Rezoning Transportation Analysis

Petition Number: 2022-140

Date	Description
1-26-23	First Review (PDM)

RZ1.0

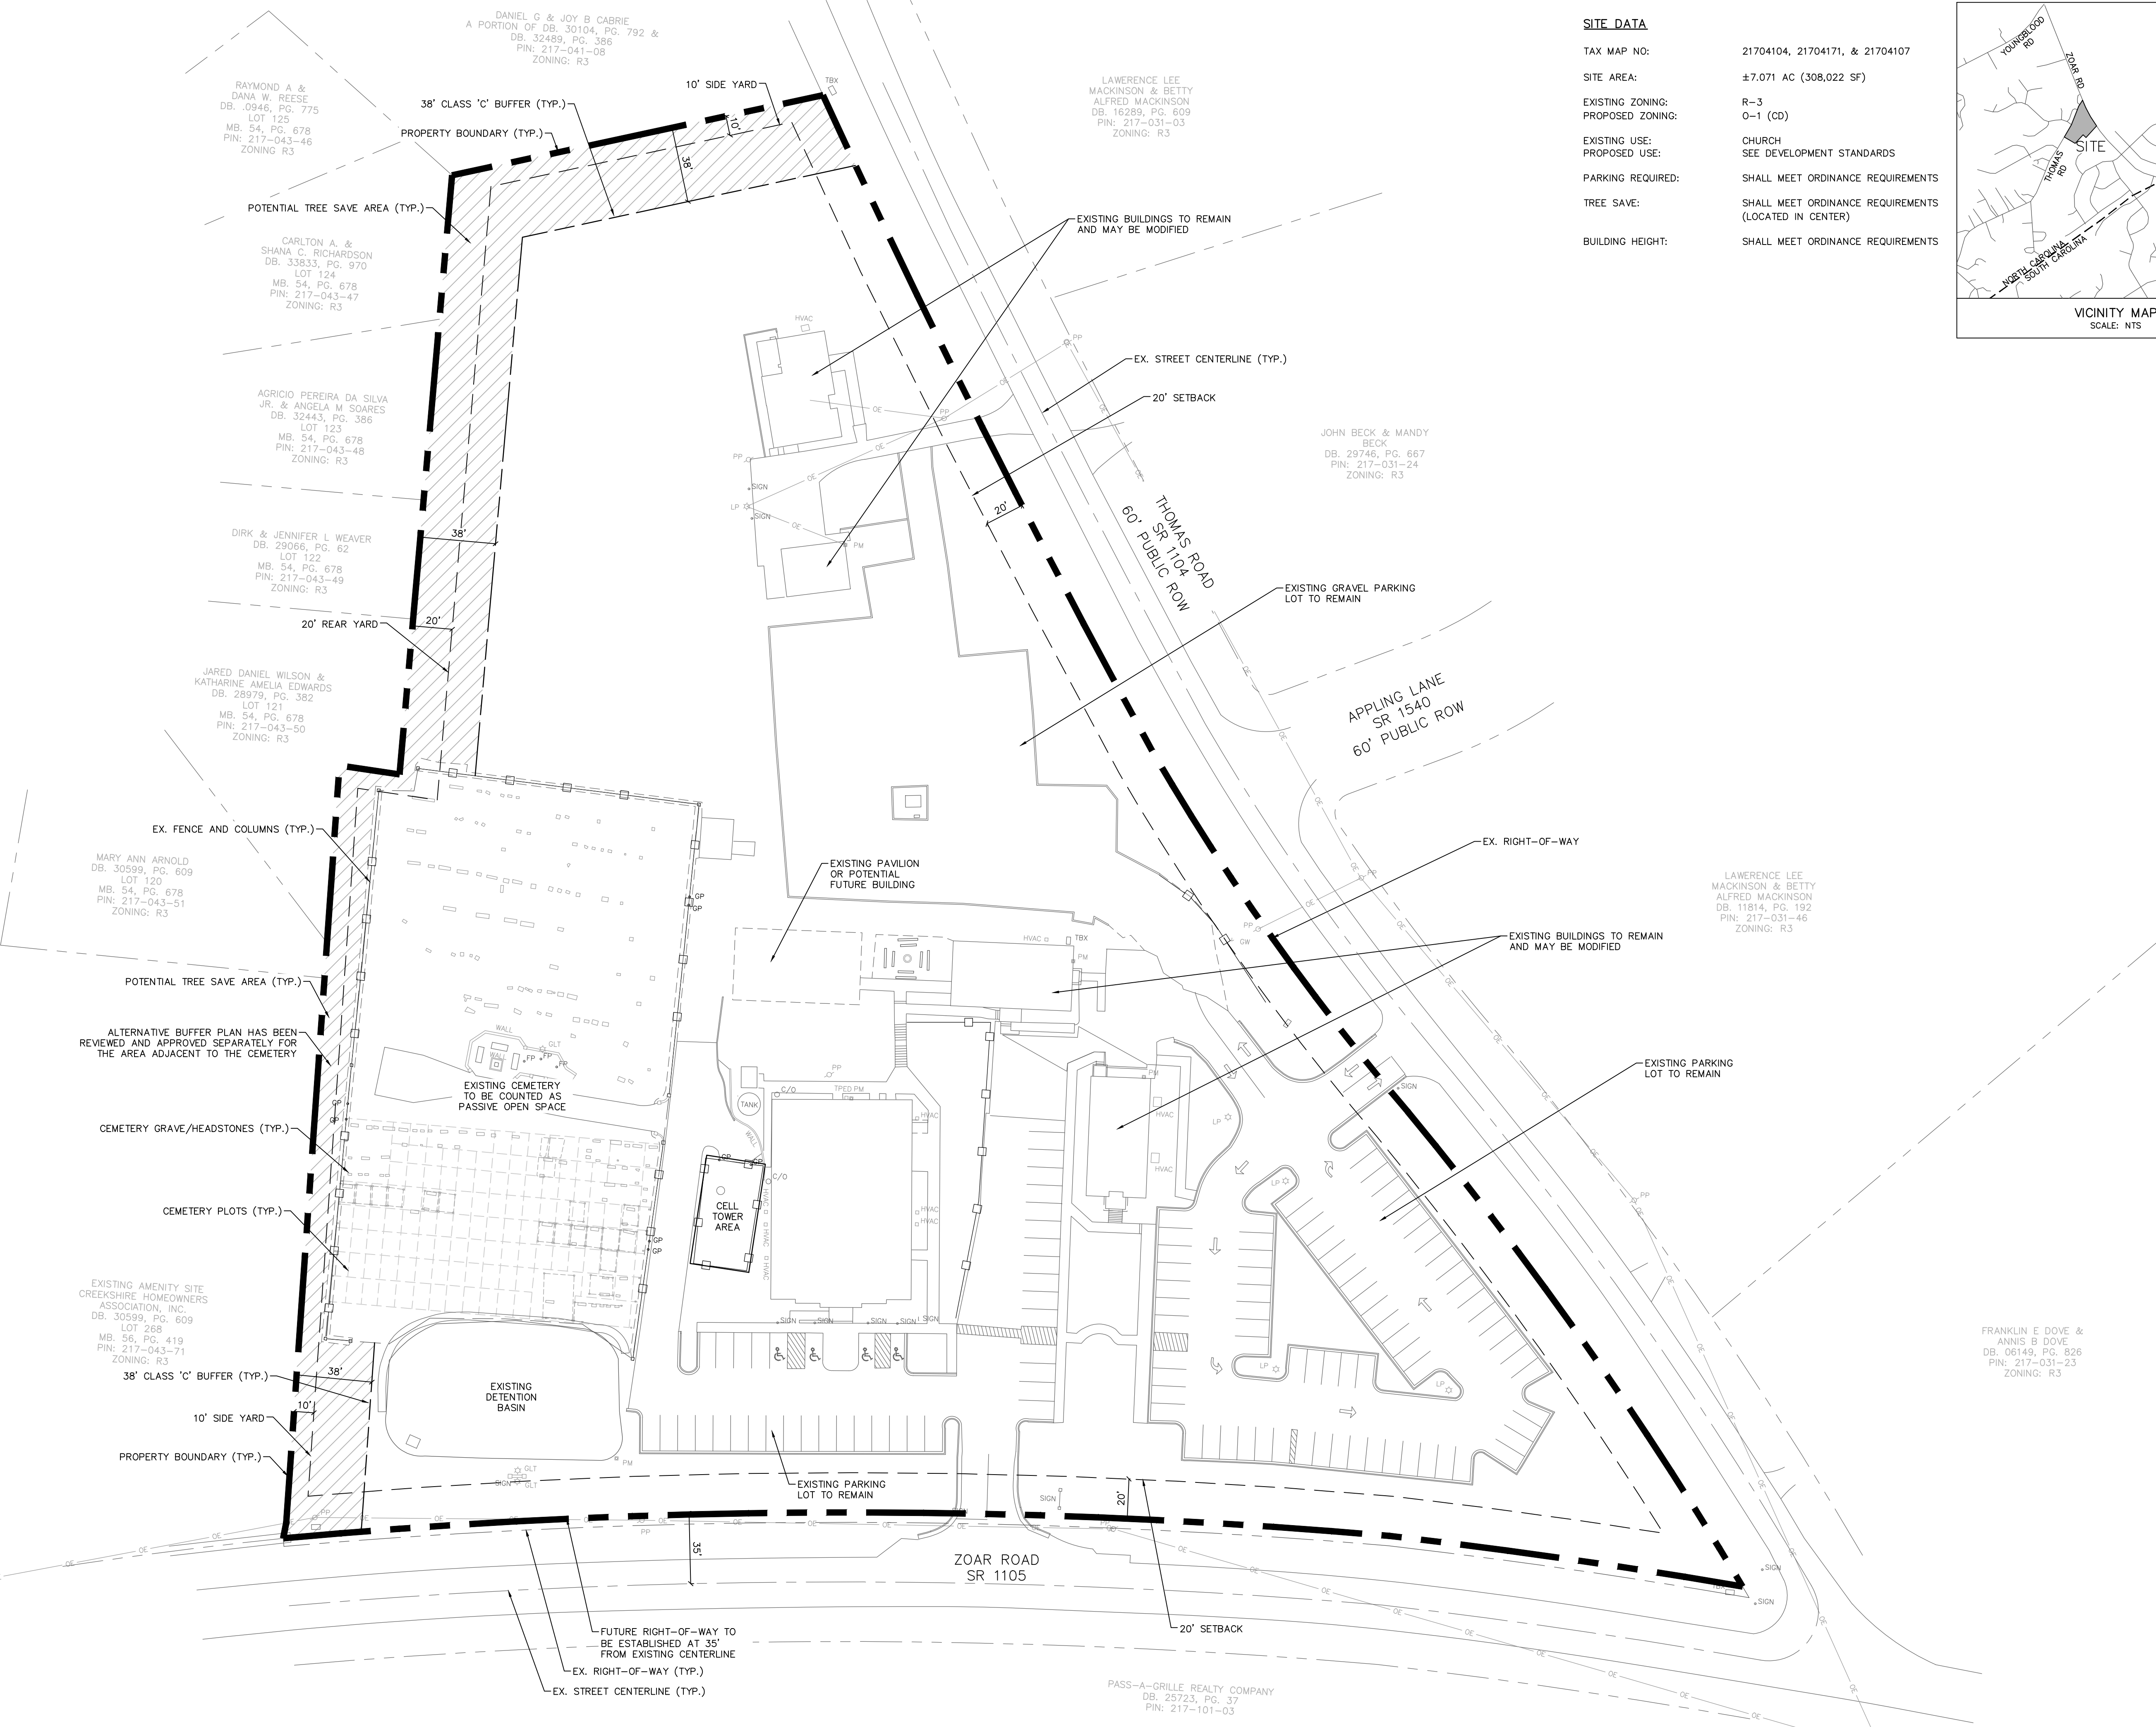
1. Curblines:

Zoar Road: Location of curb and gutter to be located 19 feet from roadway centerline to accommodate the Charlotte Streets Map with a roadway typical section of a two plus lane avenue with shared use path.

Thomas Road: Location of curb and gutter to be located 17.5 feet from roadway centerline to accommodate the Charlotte Streets Map with a roadway typical section of a two plus lane avenue with sidewalk. The location of curb and gutter is in accordance with CLDSM U-06 for local collector.

Label and dimension the curb and gutter from the centerline for each road on the site plan.

3. Revise site plan and conditional note(s) to commit to dedicate 35 feet of right-of-way from the road centerline on Zoar Road. The site plan shall label and dimension the right-of-way from the road

centerline. If greater than 35 feet of right-of-way exists dimension the existing right-of-way from the road centerline.

4. Revise site plan and conditional note(s) to commit to construct an 8-foot planting strip, and 6-foot sidewalk on Thomas Road per Chapter 19. The site plan shall label and dimension both items from the back of curb and gutter or edge of pavement.

5. Revise site plan and conditional note(s) to commit to construct bicycle facilities by installing a 12' multi-use path on Zoar Road to meet the Council-adopted Charlotte BIKES Policy. Multi-use paths maintained by the City shall meet ADA/PROWAG requirements.
